Application number: 2025/93452	
What is the application for?:	Erection of detached dwelling and associated works (modified proposal)
Address of the site or building:	Land adjacent, 28, Stringer House Lane, Emley Moor, Huddersfield, HD8 9SU
Postcode:	WF7 5LN

Type of comment: An objection	
Do you wish your comments to be published on the website anonymously?	Yes

Proposed Side Elevation (North)  
 1:100

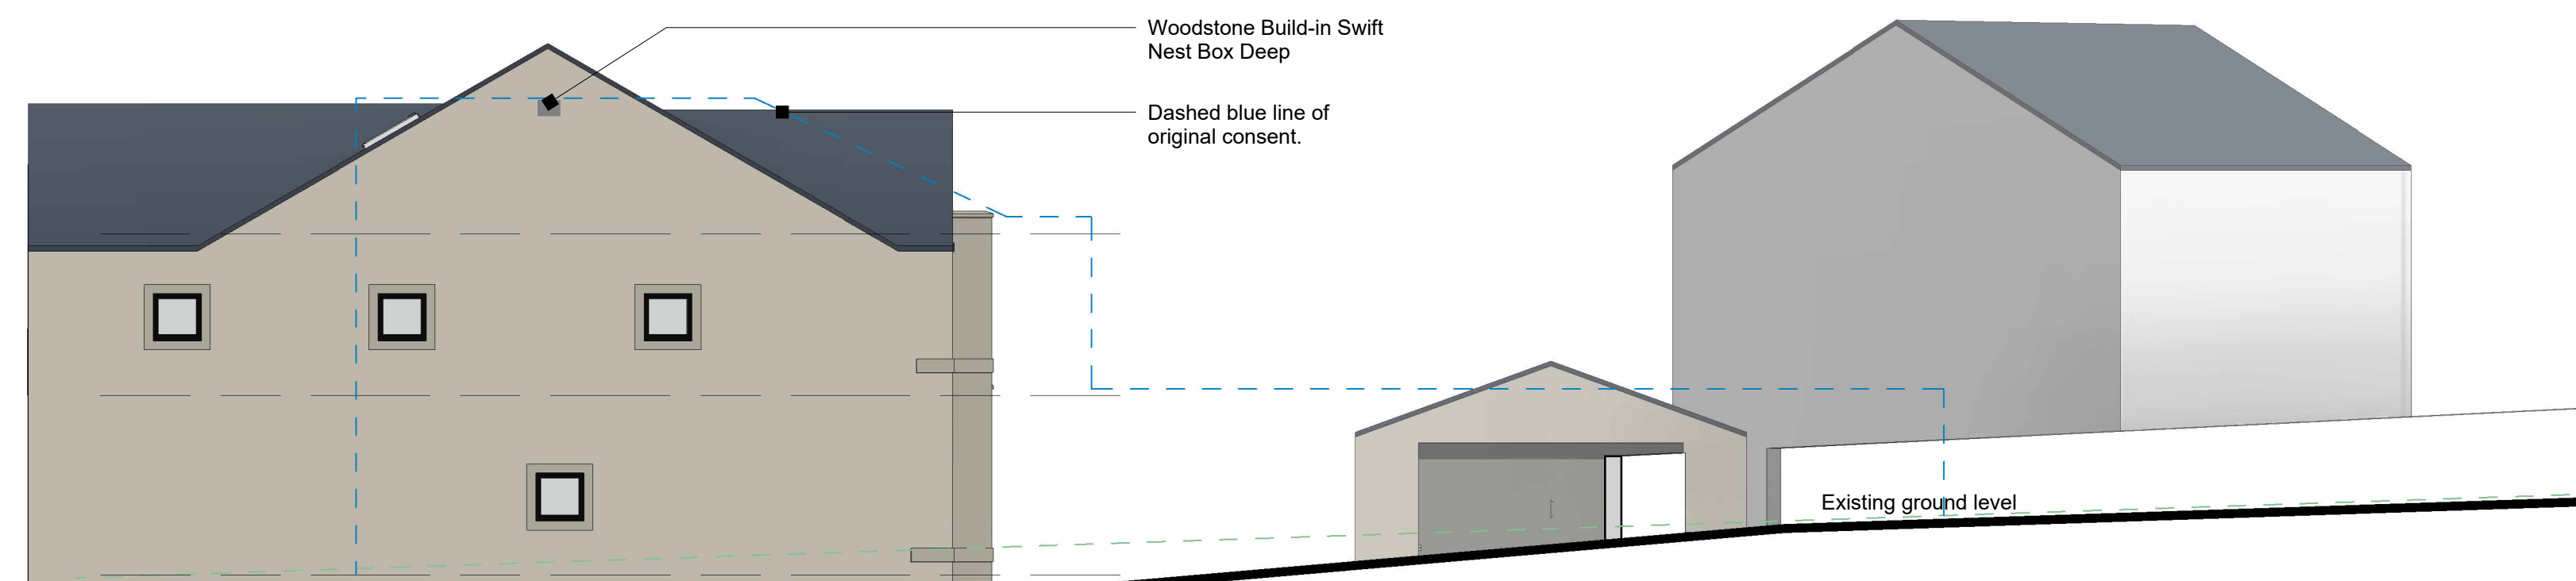
The proposed development, specifically the windows on the north elevation, would directly overlook our property. This would result in a significant loss of privacy to our home and garden, particularly affecting habitable rooms and enjoyment of our private outdoor space.

The positioning and orientation of these windows would create clear and direct sight line into our property, which we believe constitutes an unacceptable level of overlooking. This impact would be detrimental to our residential amenity and contrary to planning policies that seek to protect neighbouring properties from loss of privacy.

We respectfully request that the planning authority carefully considers the adverse impact of the north elevation windows. If the application is to be approved, we would ask that appropriate mitigation measures be required, such as obscure glazing, non-opening windows or amendments to the window positioning to prevent overlooking.
